Application: UTT/23/2162/HHF

Location: Casa Mia Stortford Road Clavering CB11 4PE

Proposal: Proposed redevelopment of first floor roof including raising the roof, repositioning roof lights and installation of solar panels.

Holding objection due to insufficient ecological information on European Protected Species (bats)

CLIENT: Mr J. STEPHENS & Miss K. BERNARD
PROJECT TITLE: CASA MIA STORTFORD ROAD CLAVERING CB 11 4 PE
DRAWING TITLE: PROPOSED FRONT ELEVATION
DRAWING NO: P/ 16
DATE: 14. 10. 2023
REVISION: - B
SCALE: 1 : 50 @ A3
DRAWN: KB

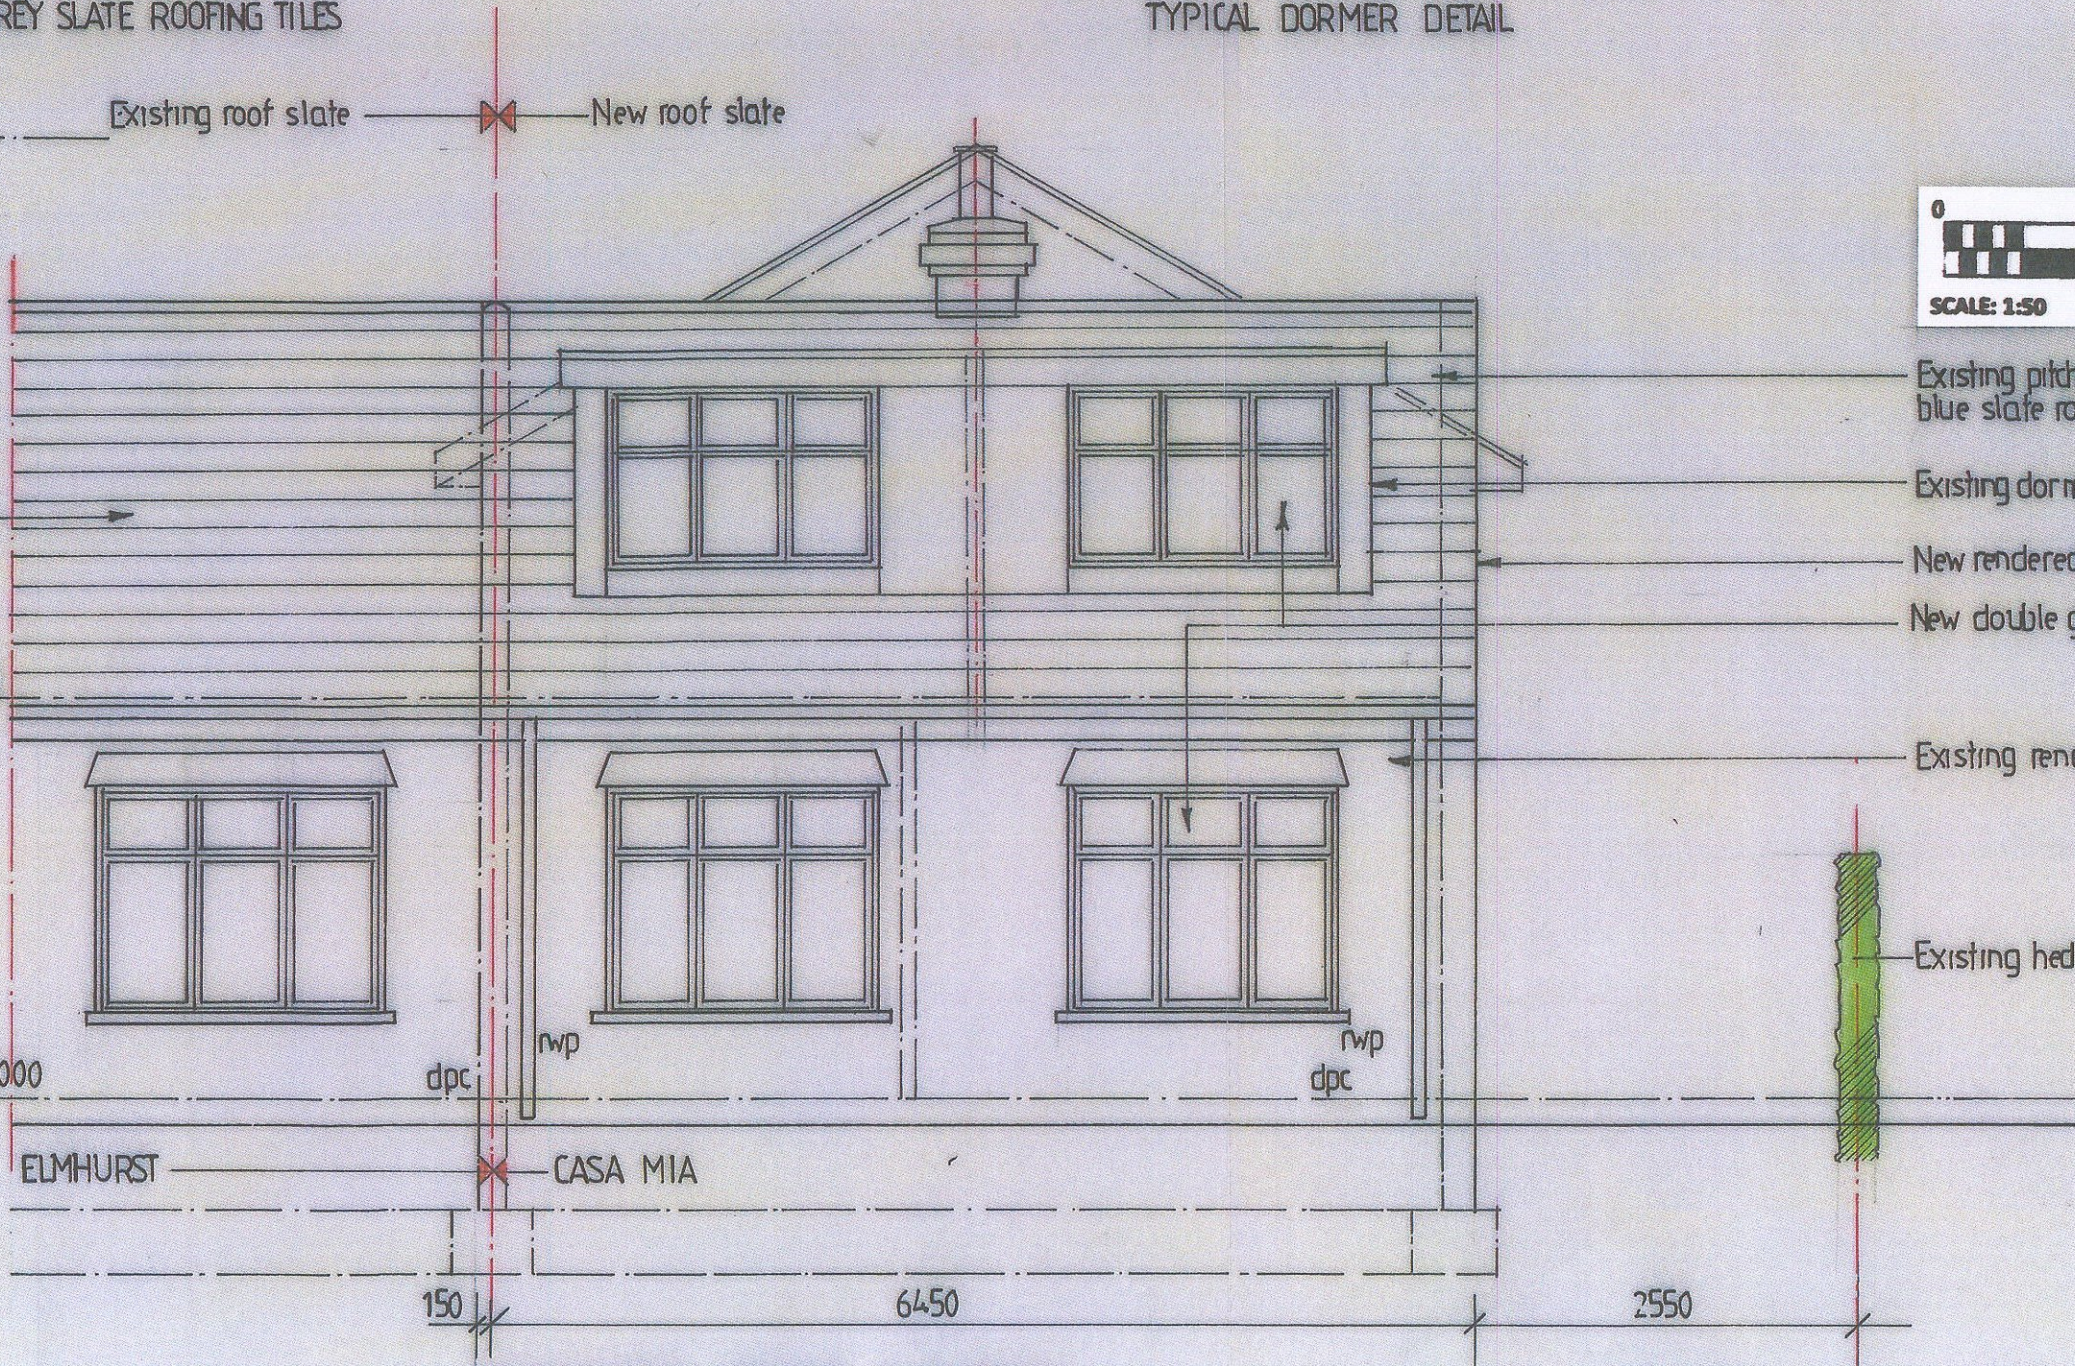
We are not satisfied that there is sufficient ecological information available for determination of this application. The proposed extension impacts a lined slate roof and an existing dormer with hanging tiles, both of which have the potential to support roosting bats. With suitable foraging habitat within the nearby mature gardens, there is an elevated risk of bats being present and an ecological assessment has not been undertaken. We recommend that a suitably qualified ecologist undertakes a Preliminary Roost Assessment (PRA) of the existing building to assess if bat roosts are present and if the proposals will directly, or indirectly, impact bats. The survey can be undertaken at any time of year and should follow best practice guidelines (Collins, 2023). We recommend that details of survey methods, results and any mitigation and

enhancement measures are detailed within the survey report. If the building is considered to have the potential to support roosting bats, then further surveys such as emergence/re-entry surveys should be undertaken, in line with best practice guidance (Collins, 2023), the results of which will be required prior to determination. [A Householders' Guide to Engaging an Ecologist | CIEEM](#) may help the applicant.
